HERITAGE ADVICE RESPONSE TO SSDA RFI (SSD-77260958)

TO	Owner: NSW Housing Corporation Pty Ltd Architect: PTI Architecture	DATE	14 November 2025
PROJECT	<i>Mixed-Use Development with Infill Affordable Housing at 2-4 Burleigh Street & 20-24 Railway Parade, Burwood</i>	REF.	OUR REF: 2404 HAR:JT:WG
FROM	Tropman & Tropman Architects (TTA) Wan Hoe Goh	TOTAL PAGES	3

PODIUM ARTICULATION

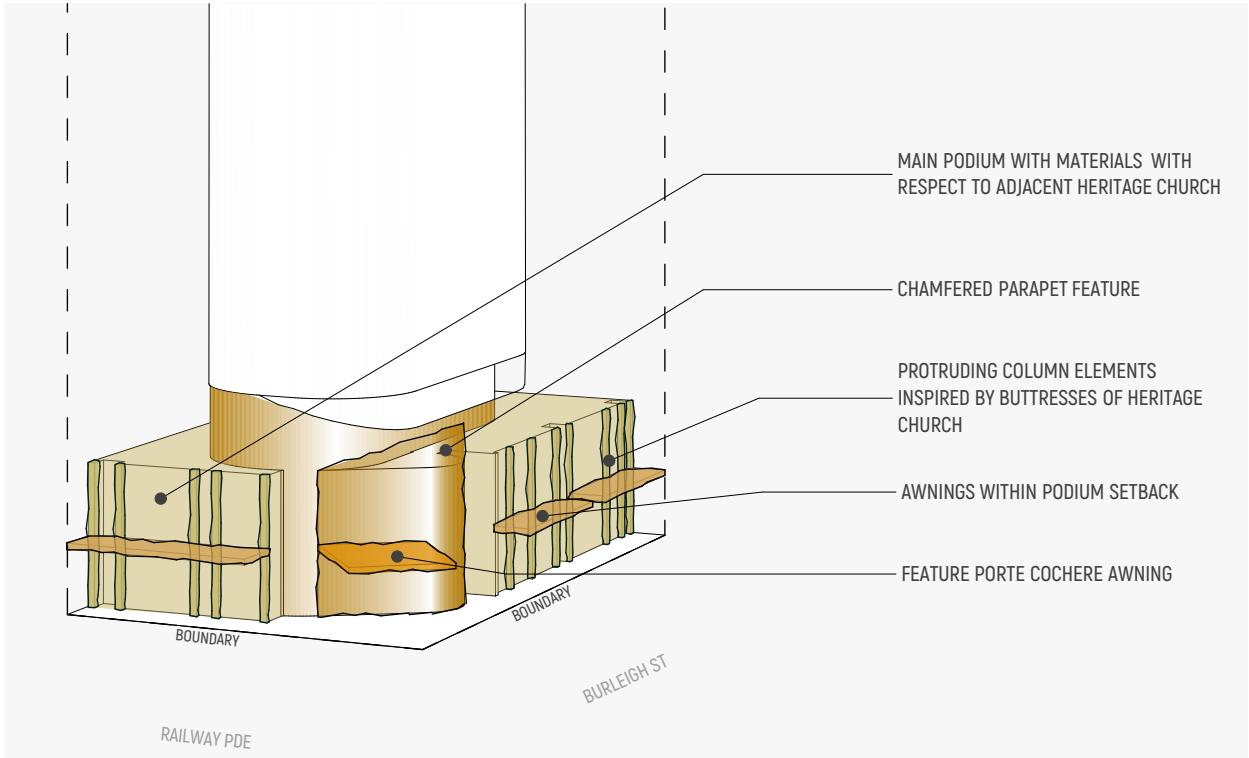
3.4 *“The development has not provided an adequate setback from the north-west corner to provide curtilage to the church to the west that is listed as a local heritage item.”*

The north west corner is splayed and setback to provide a clear view of the adjacent church local heritage item when viewed along the Railway Parade view corridor.

Figure 3 – Proposed Driveway servicing Basement Level (Source Architectural Plan Prepared by PTI Architects)

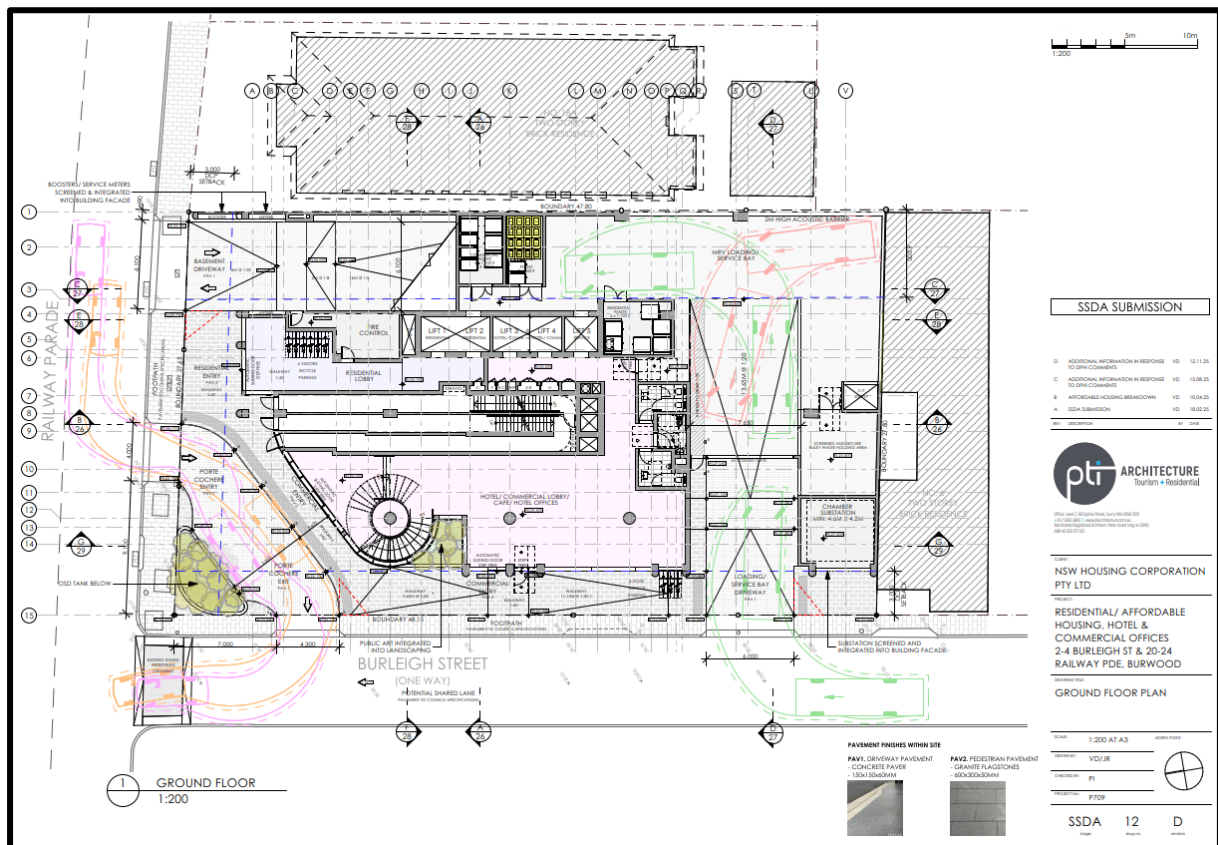
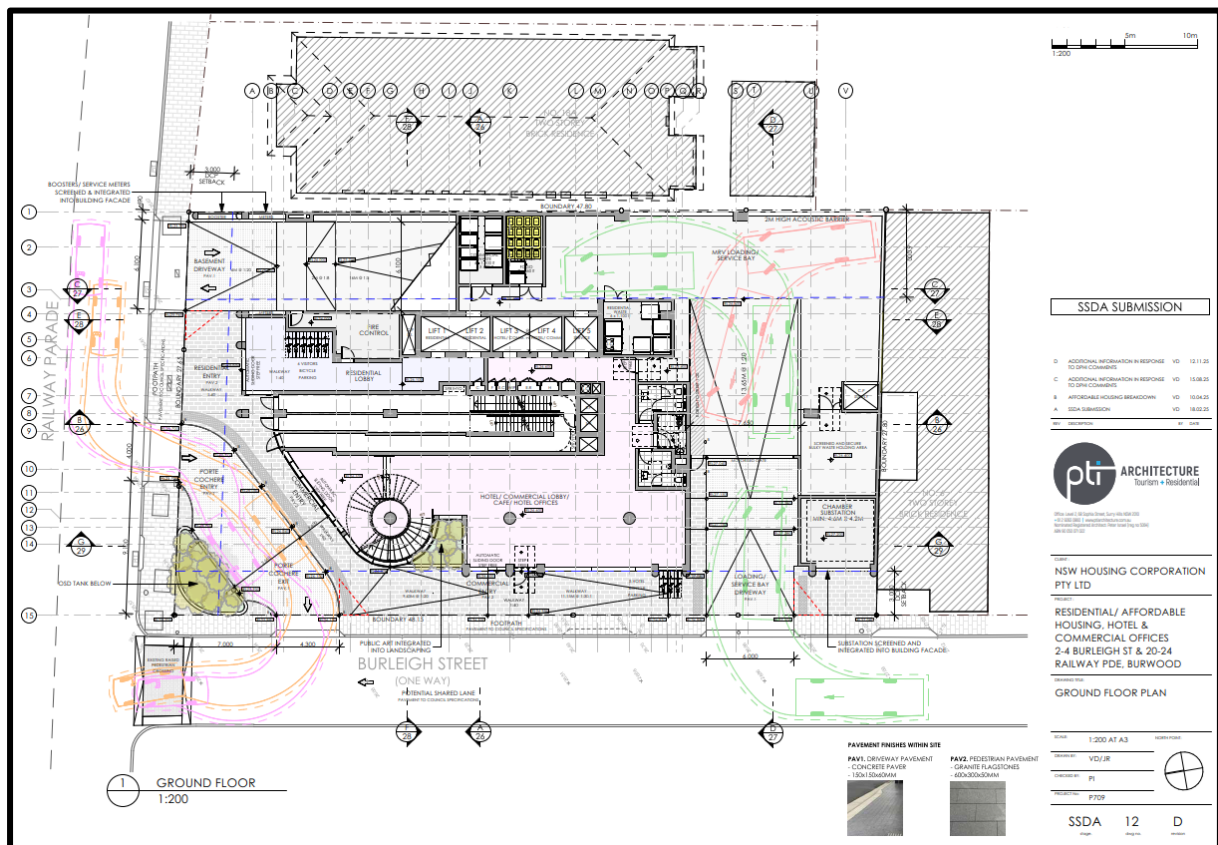
3.2 *“In addition, the design of the vehicular entrances to suit the building use does not reflect the subdivision pattern of rear lanes (night soil lanes) and small front gardens. The Porte-Cochere form is not considered to be appropriate within the context of surrounding heritage items.”*

The revised proposed development has considered the design of the vehicular entrances and have improved the basement driveway entry and exit at Railway Parade, with the driveway being perpendicular to the vehicular crossover. This has improved the access and sightline for vehicles exiting the car park.
